Online Comment

Application H16-0882-25
Location 65 HOLBEACH ROAD SPALDING PE11 2HY
Proposal Change of use from a single dwelling to dental surgery including alterations, additional gravel parking, improvements to existing access and plant shed

Name Spalding & District Civic Society
Address Spalding

Date Submitted 03-10-25
For/Against Support

Proposed West Elevation 1:100

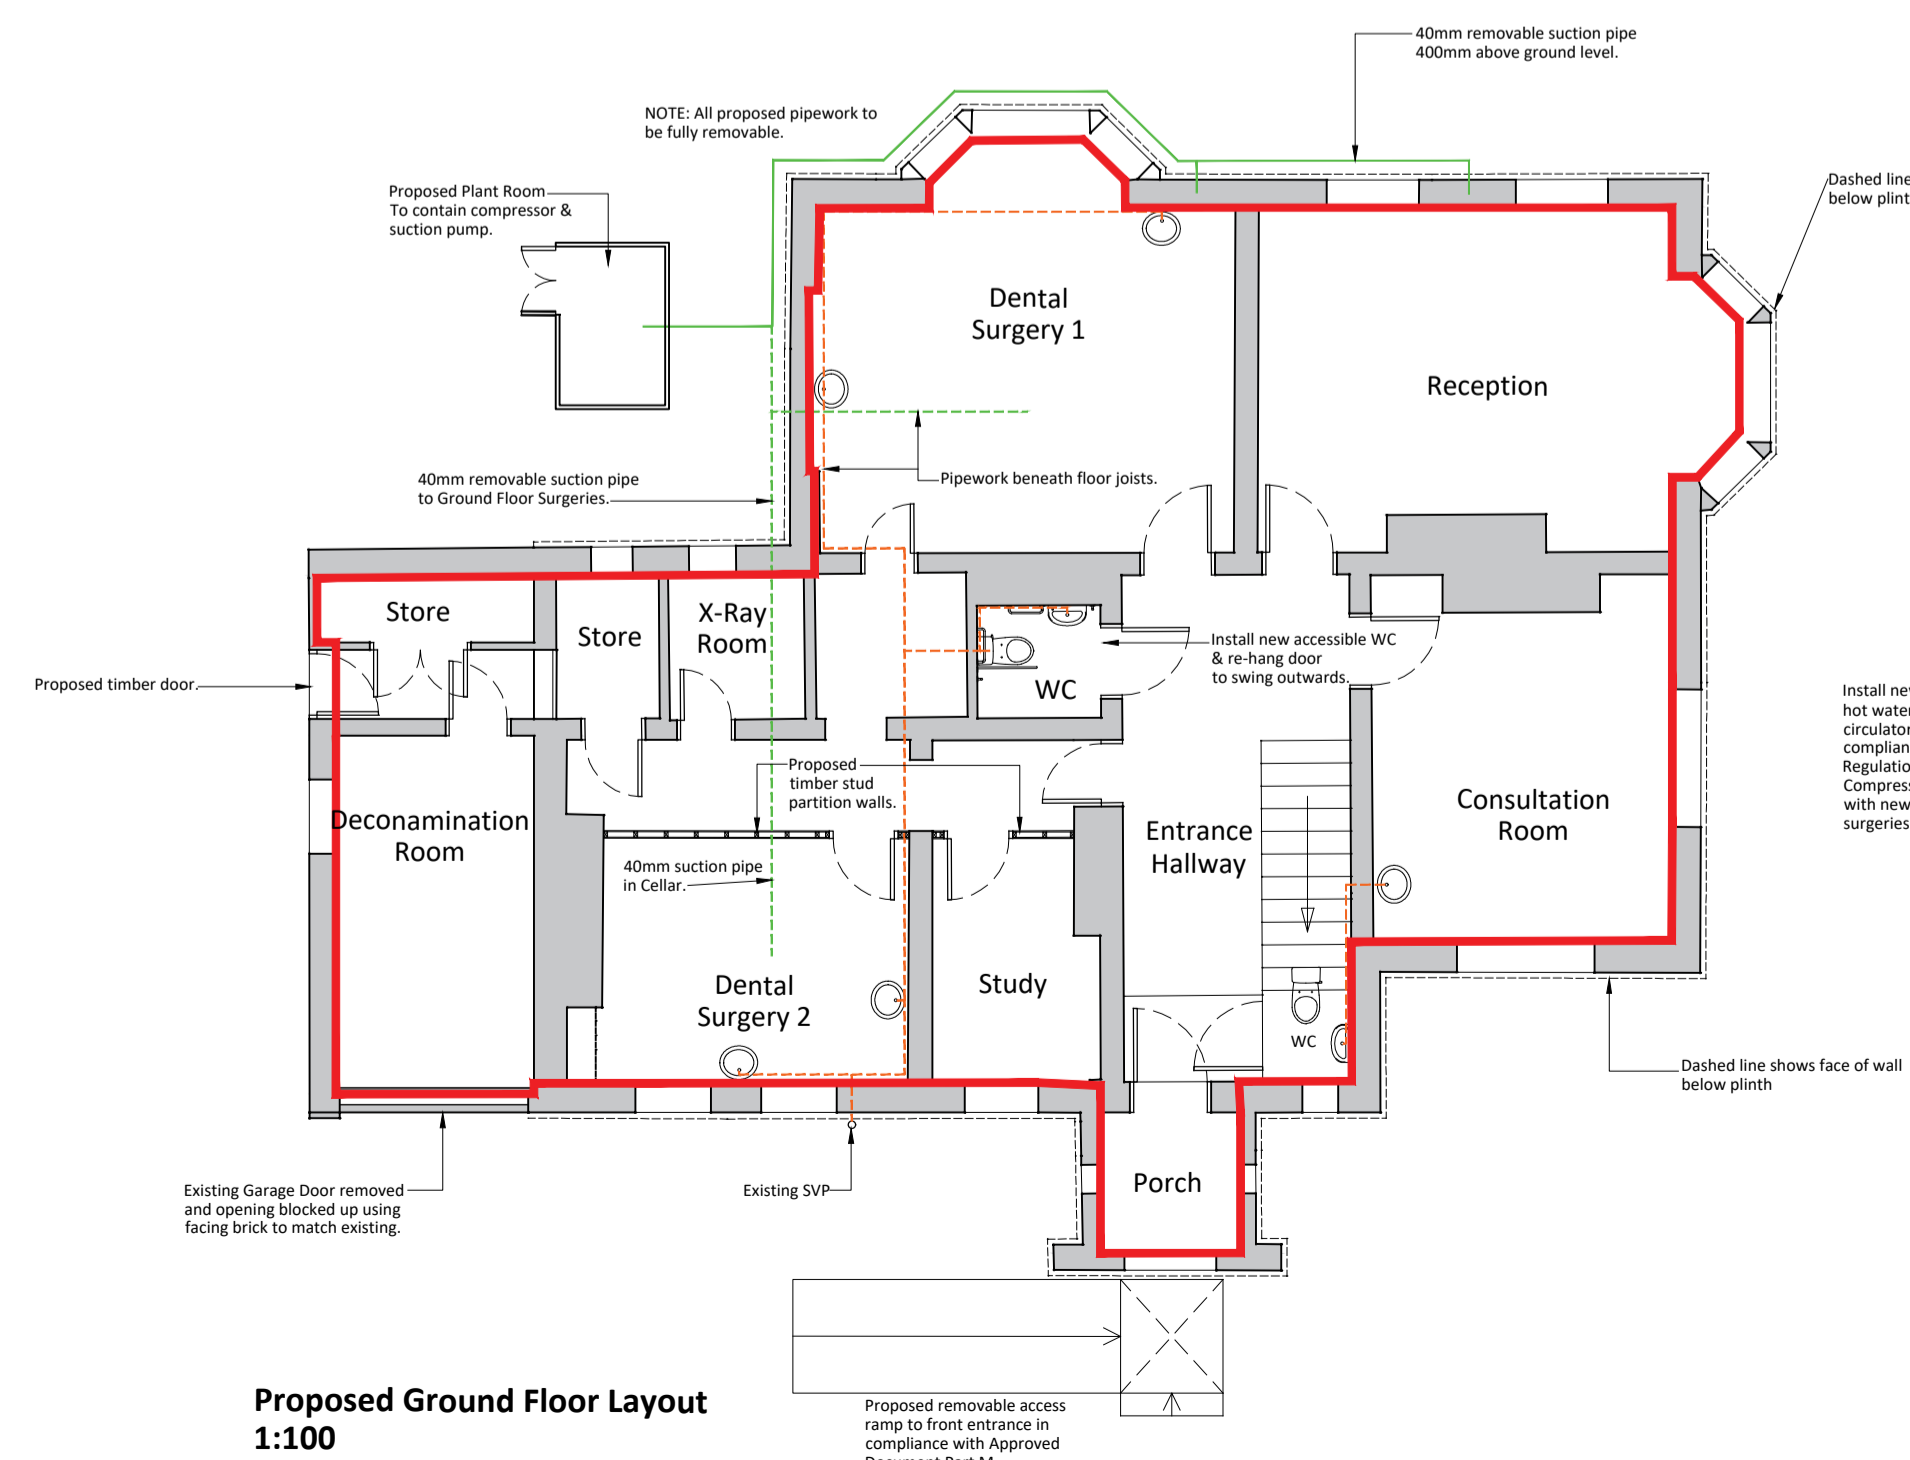
The property has been un occupied for a considerable amount of time, (presumably the former Vicarage) and it is considered that the proposed use, which retains the external facade, apart from the building up of the garage door is a viable use and much needed in the town. Care should be taken when building up the garage door opening to make sure that reclaimed bricks are used of a similar size and colour to the existing. Perhaps a narrow hedge could be introduced to lessen the impact.
